Address: House number.....3

Henge Close, Adderbury, OX17 3GA

### Planning Application 19/02796/FULL OS Parcels 3309 & 4319 adjoining LNMR

Further to our previous letter of objection earlier this year please find below our additional response to the latest published amendments which include the site layout, car park lighting, roller shutters to the pavilion, MUGA fencing, ball stop fencing and additional tree and hedge planting.

1 North Elevation
1 : 100

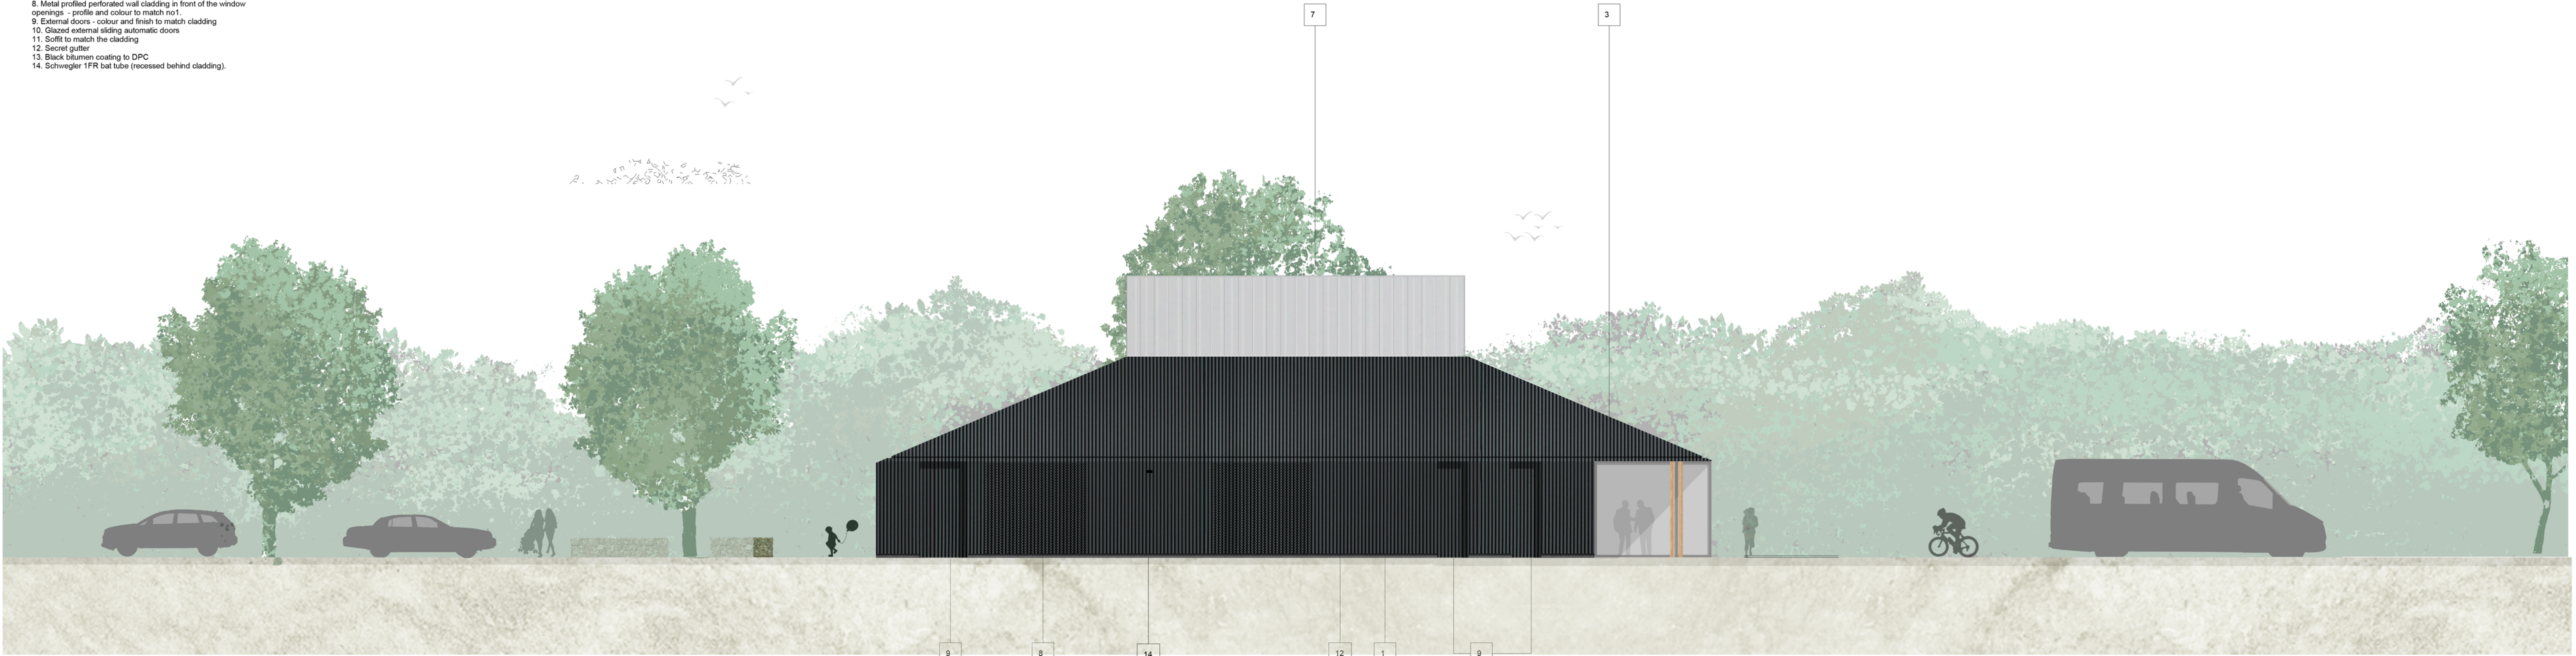
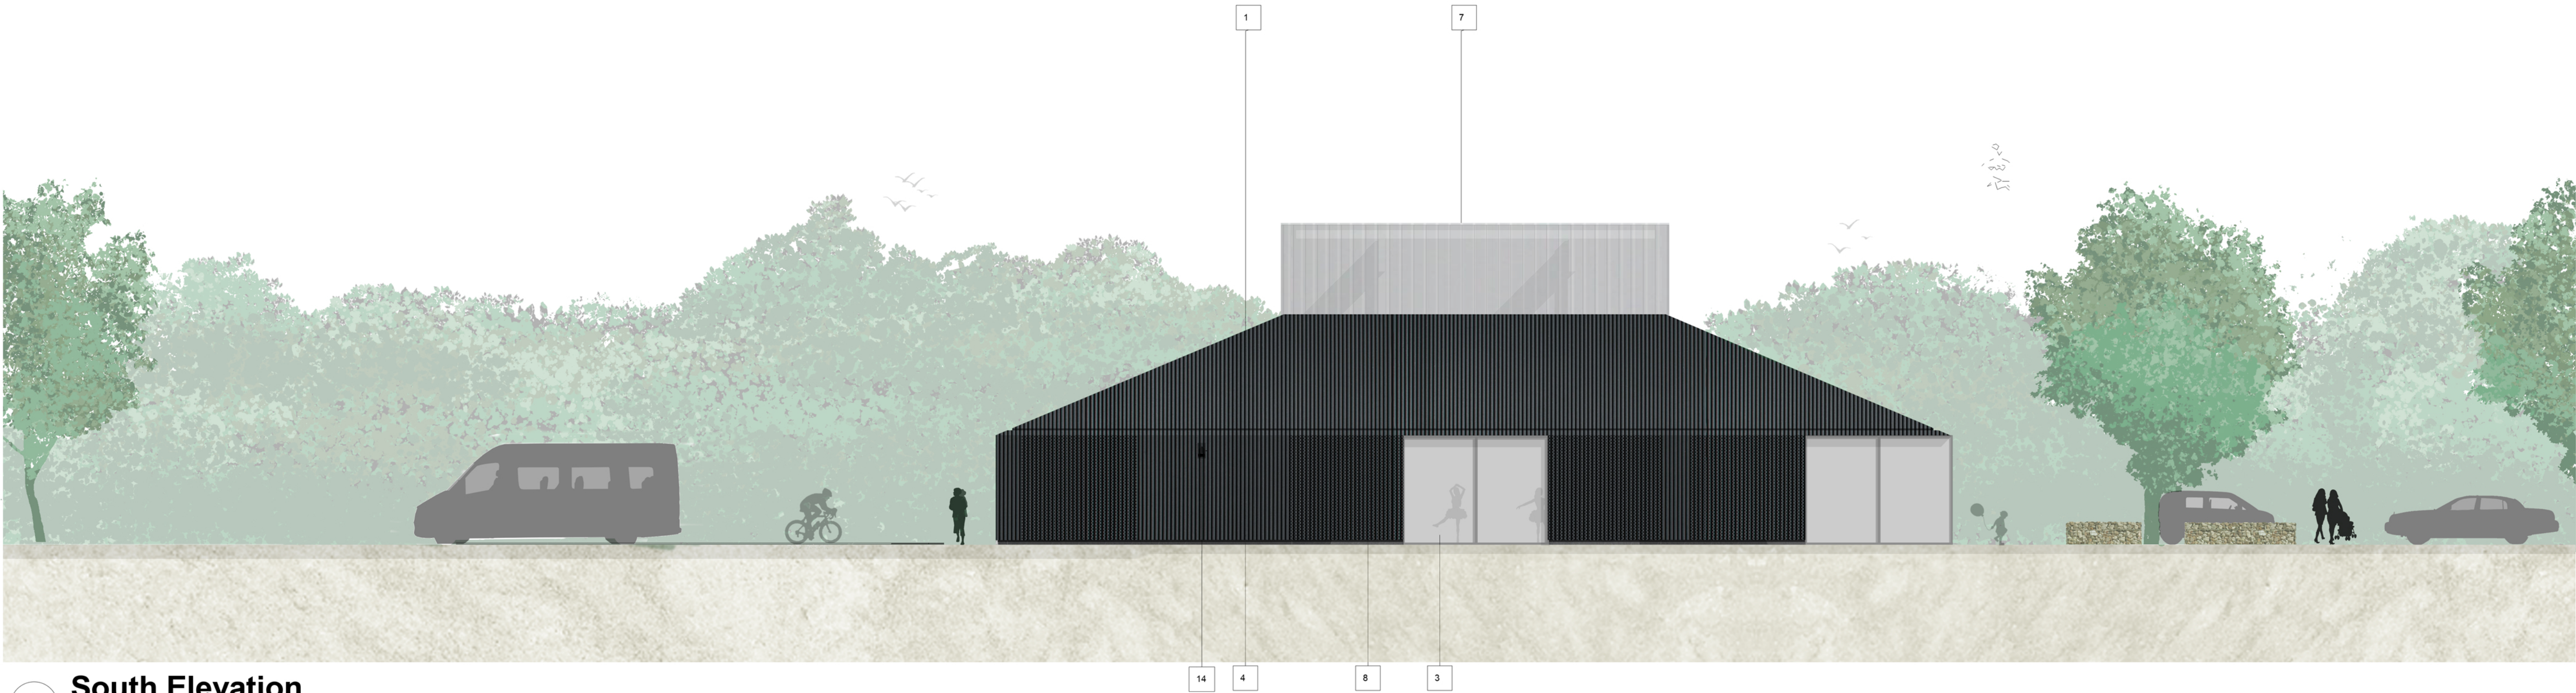
- We consider the proposed external facings of the pavilion and its construction materials ugly and inappropriate. Dark metal shutters are more suggestive of a penal facility than a vibrant community centre. The designers' claim that the dark colour will recede into the landscape like a rural barn are hard to reconcile with their assertion that it will also make a bold statement.
